DECISION DELEGATED TO HEAD OF PLANNING

Application No: H16-0157-26 **Applicant:** Mr I Andrew
Proposal: Erection of Bungalow - outline approval H16-1019-23
Location: Between Mortimer & Beaulor The Raceground Spalding
Terminal Date: 22nd April 2026

SPALDING TREE PRESERVATION ORDER NO.89 2025

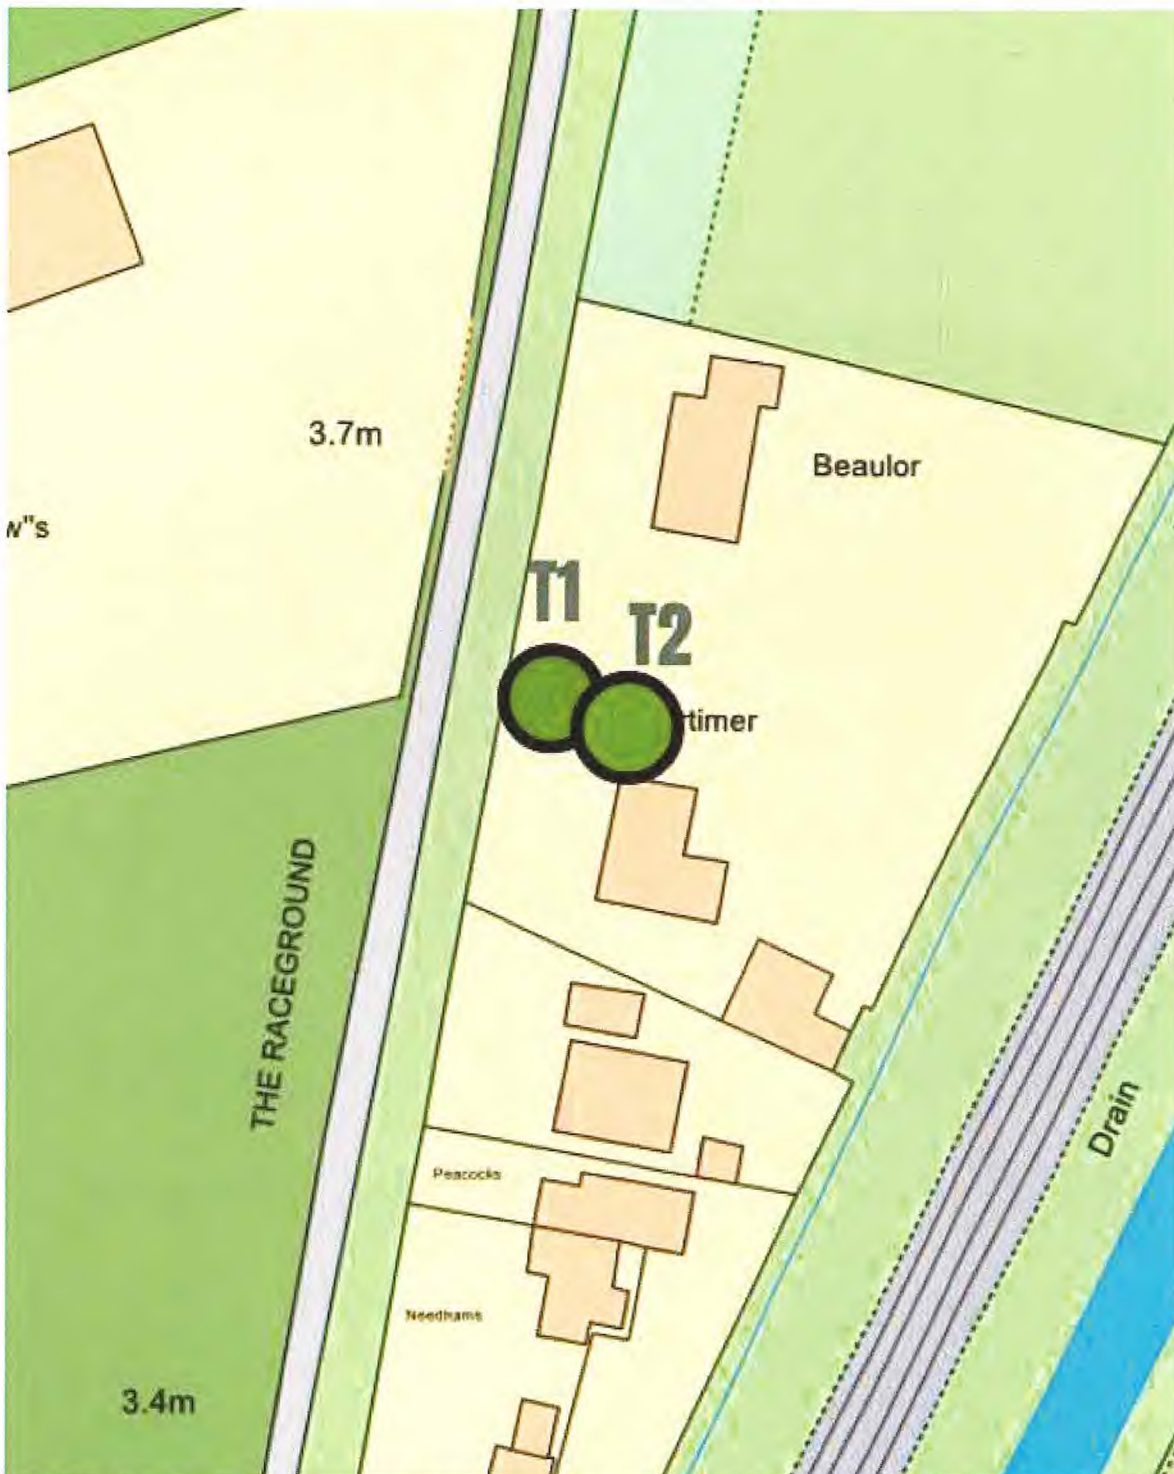
The frontage of the site is dominated by two mature apple trees whose trunks are within the curtilage of the property known as Mortimer, and which canopies encroach into the proposed site.

The Root Protection Areas of both trees require calculation as in British Standard 5837:2012. Ideally the proposed development should be re-designed so that AT LEAST the area covered by the Root protection Area of both trees is completely free of any encroachment by the proposed development. The further from the trees the footplate of the development is the better. Such trees have the potential to enhance a future development, rather than being viewed as a problem to be ignored, or even damaged.

Root Protection Areas will need to be taken into account should it be proposed to construct any pathways or the like within them. 'No dig' methods of construction would be required. Should development be allowed the trees will need fencing prior to any site clearance as in British Standard 5837:2012

1:200 SD25-026/1
OCT-25 B. GILHAM.

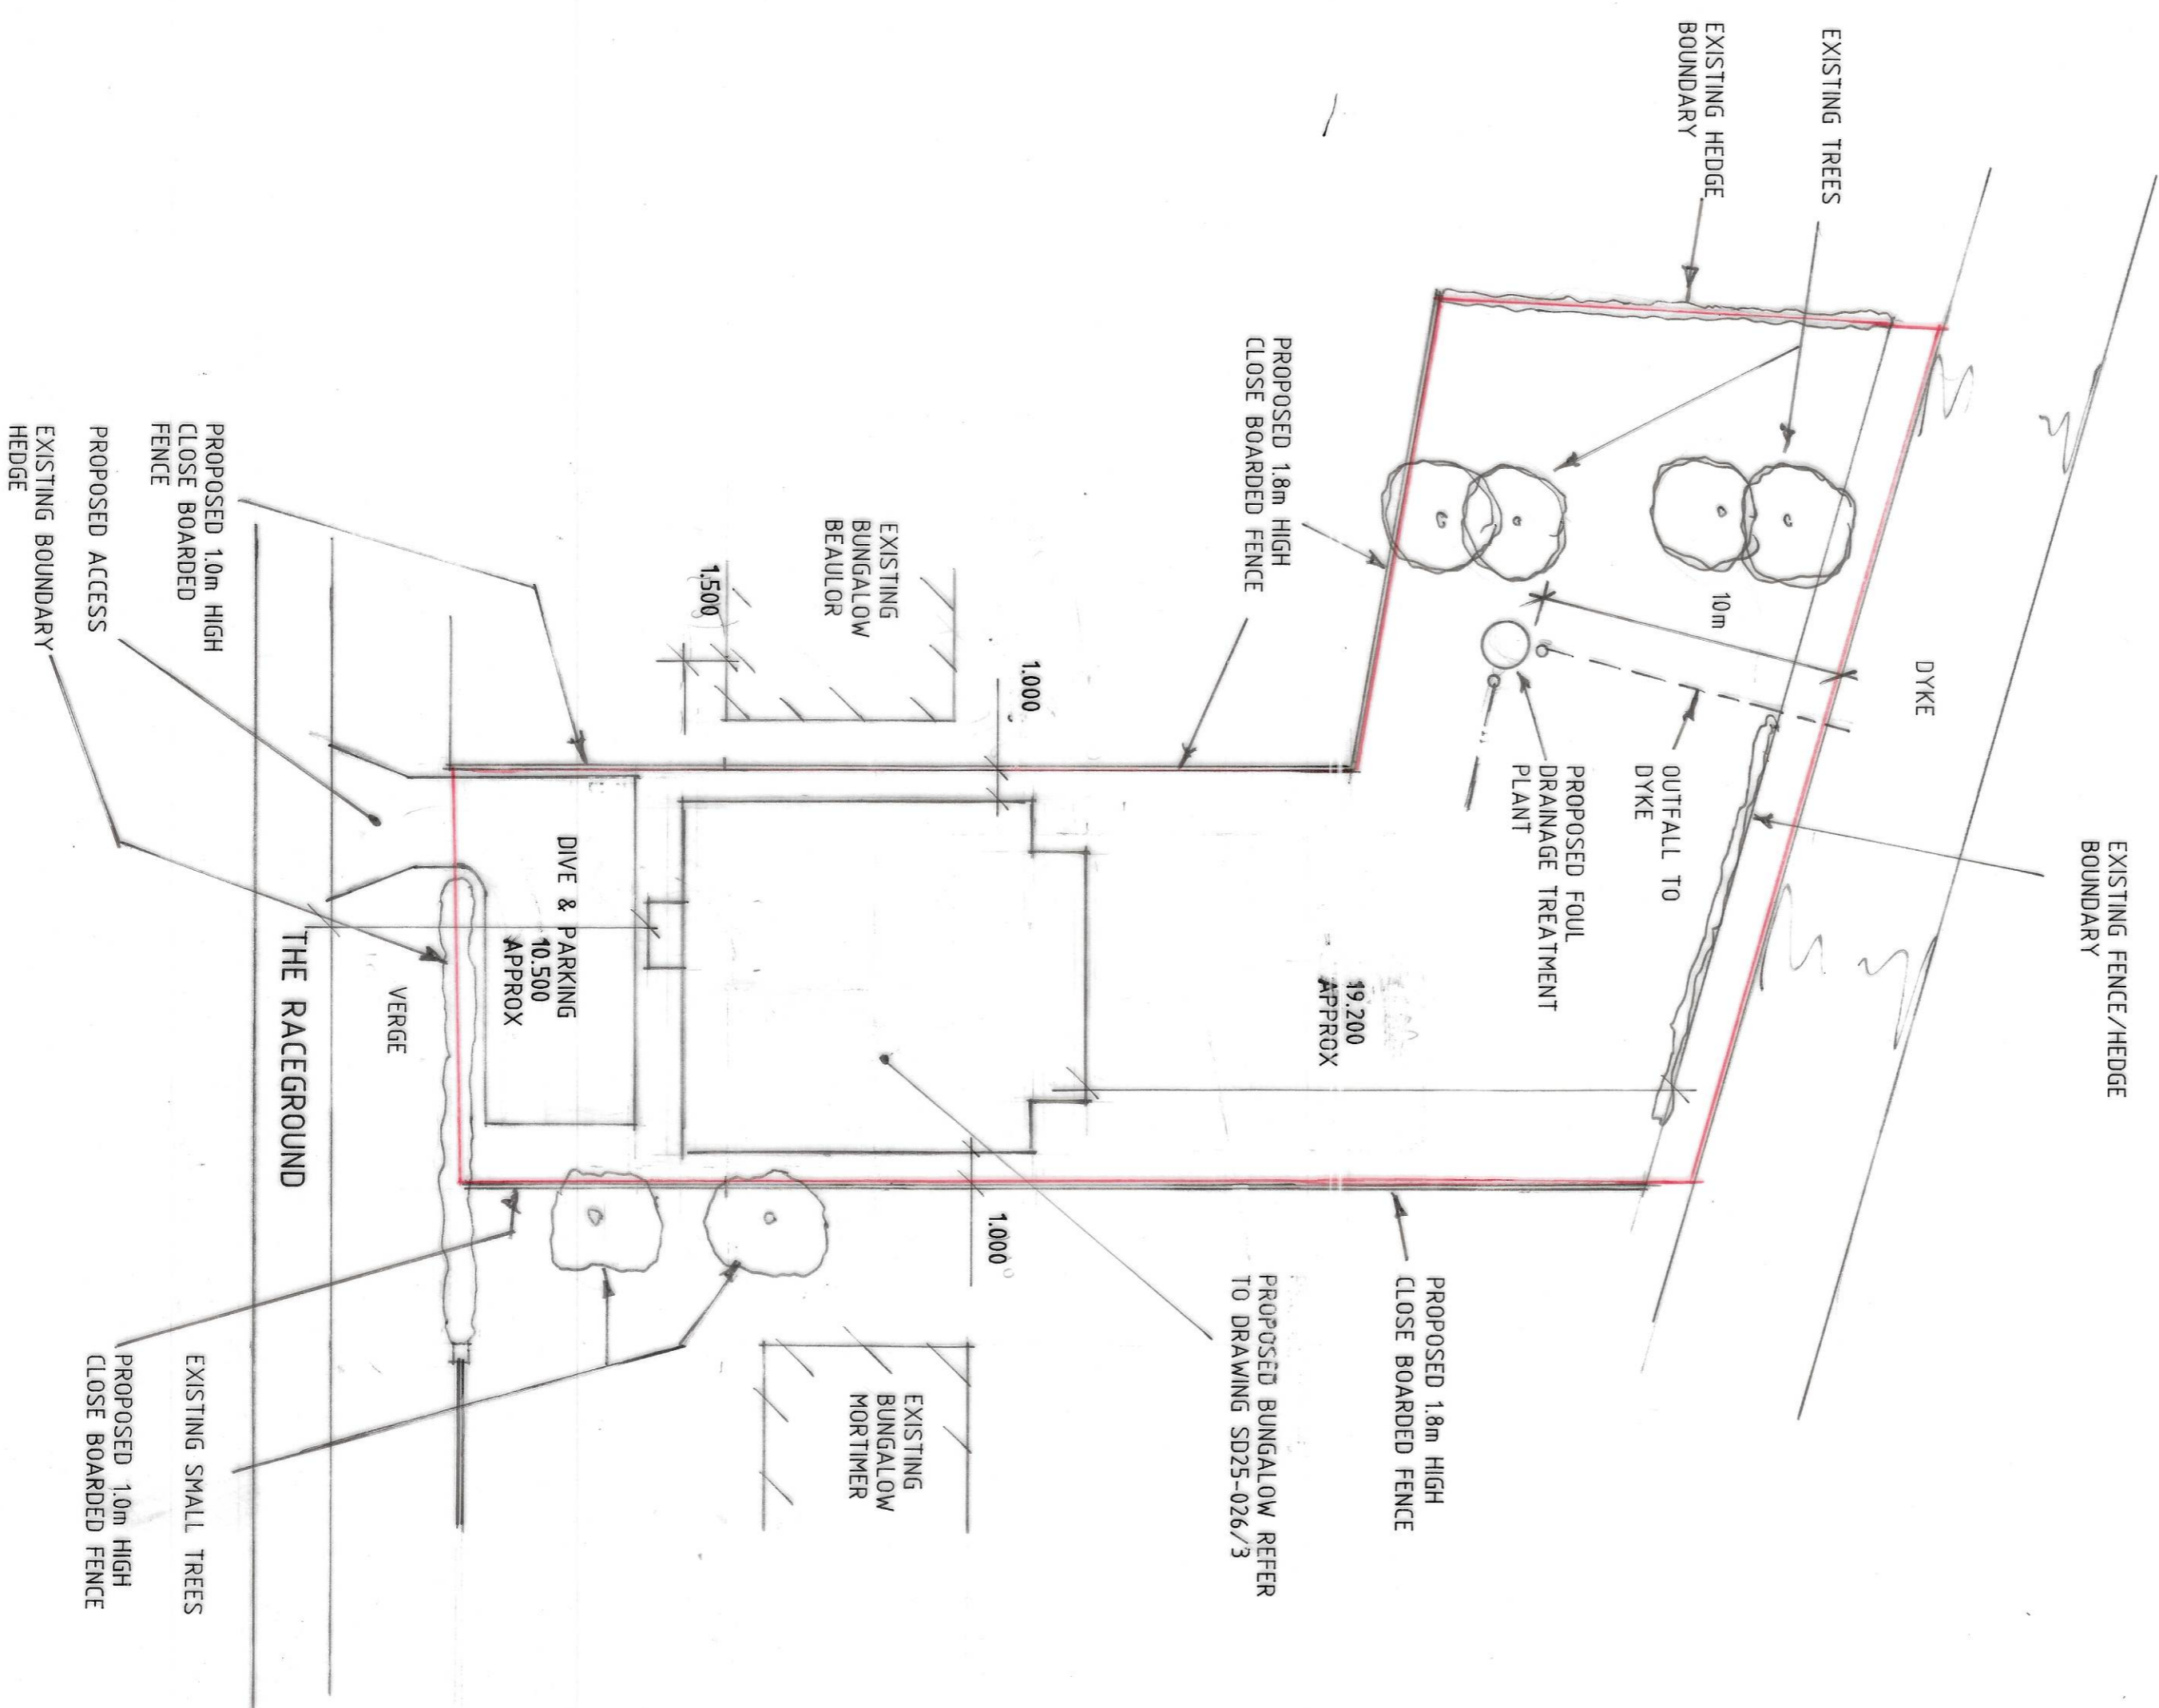
The proposed dwelling would occupy a far larger footprint than its counterparts in the immediate area. While much of this additional bulk is located to the rear, the dwelling would be positioned slightly in front of the "build line" established by the flanking dwellings. As such, the visual mass of the building would be greater than its immediate counterparts, resulting in a dwelling which appears more dominant than nearby development. Furthermore, this positioning, taken in isolation of its implication on massing etc, would appear incongruous in its own right as it would be an anomalous feature.

As finished floor levels are to be raised 0.3m, a conventional 1.8m high fence would not provide full screening from ground floor windows. However, all but two windows face the rear and front, preventing overlooking. The north facing window connects onto an en-suite and so could be obscure glazed, whilst the south facing window would only offer views of a blank elevation and an area of garden visible from the public realm, preventing harm.

Two trees with Tree Protection Orders (TPOs) along the south-western border with the dwelling Mortimer. These TPOs were put in place after the granting of outline approval. The proposed dwelling would be less than 1m from the edge of the canopy as shown on the submitted block plan (SD25-026/1).

The proposed dwelling would therefore appear to be within the root protection area of the protected trees. No construction plan or equivalent as to how to minimise impact has been provided. Likewise, no arboriculturist report has been provided to quantify harm (or lack thereof). On this basis, it cannot be assured that the proposal would have an unacceptable impact upon the TPOs, and therefore, on the balance of probabilities, harm is assumed to be caused.

1:100 1:50 SD25-026/3  
 JAN-26 B. GILHAM

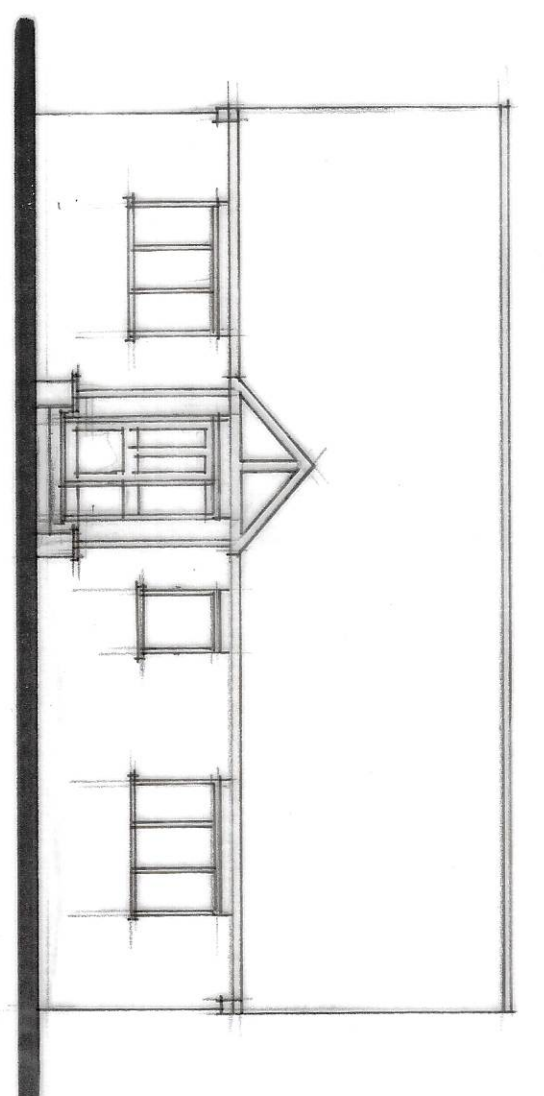
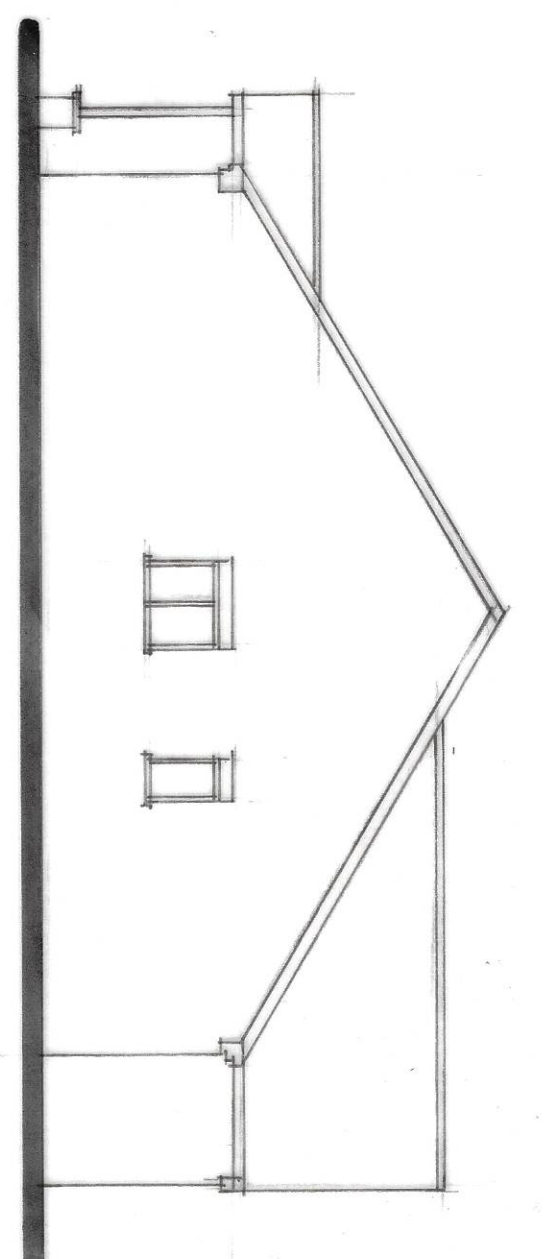
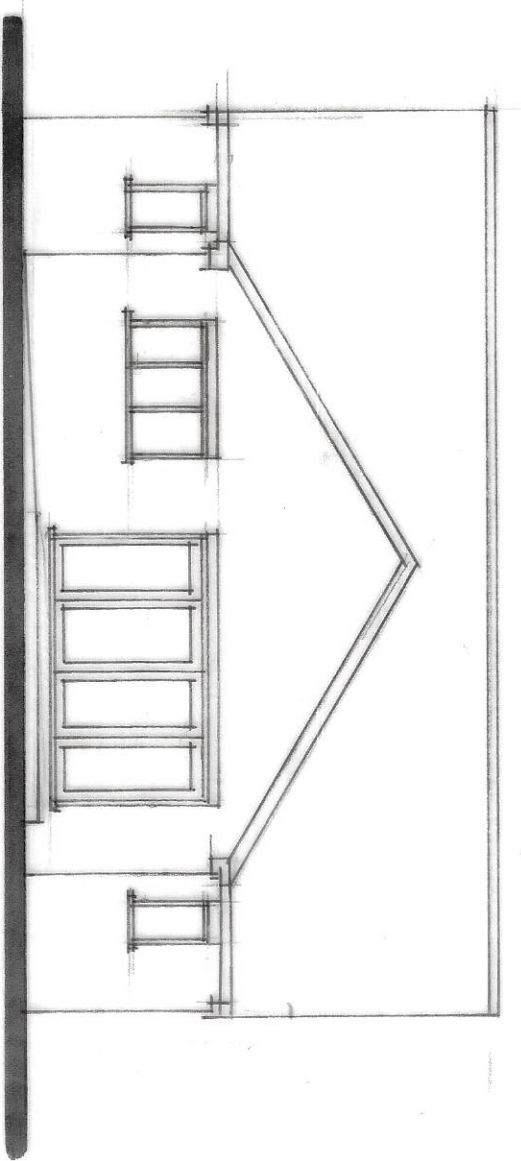
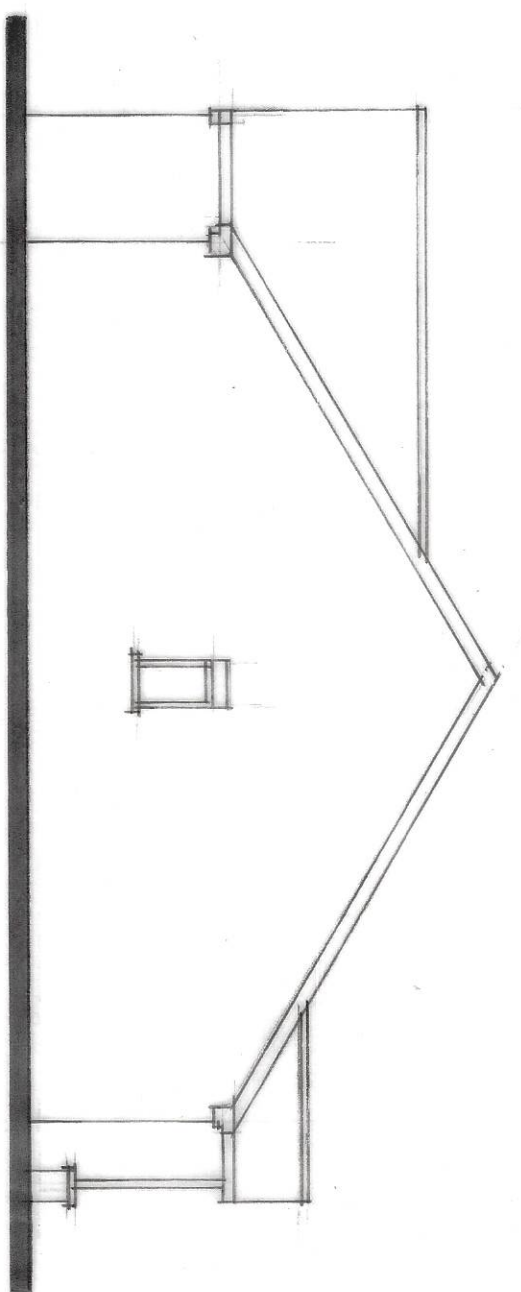
This is a Reserved Matters application following outline approval H16-1019-23. A three-bedroom bungalow is proposed. It would measure 11.86m (width) by 13.4m (depth), with an overall footprint of 152sqm. To the eaves, the height would be 2.875m, rising to 6.25m at the apex.

The height of the dwelling, at 6.25m, is relatively tall for a bungalow. That being said, it is not an overly tall proposal for a bungalow with storage in the roof. Whilst the houses either side are bungalows, beyond that there are two storey dwellings, preventing a consistency of heights in the area. However, when this height is conjoined with the significant mass of the building, and its projection to the front of the dwelling, the result is a highly impactful development, which appears significant in size, particularly compared to the two adjacent dwellings. This results in a degree of harm.

Taken in isolation of its scale, the actual design of the dwelling is basic. It would make little contribution to the character of the area, and whilst not harmful, would not benefit the architecture of the area.
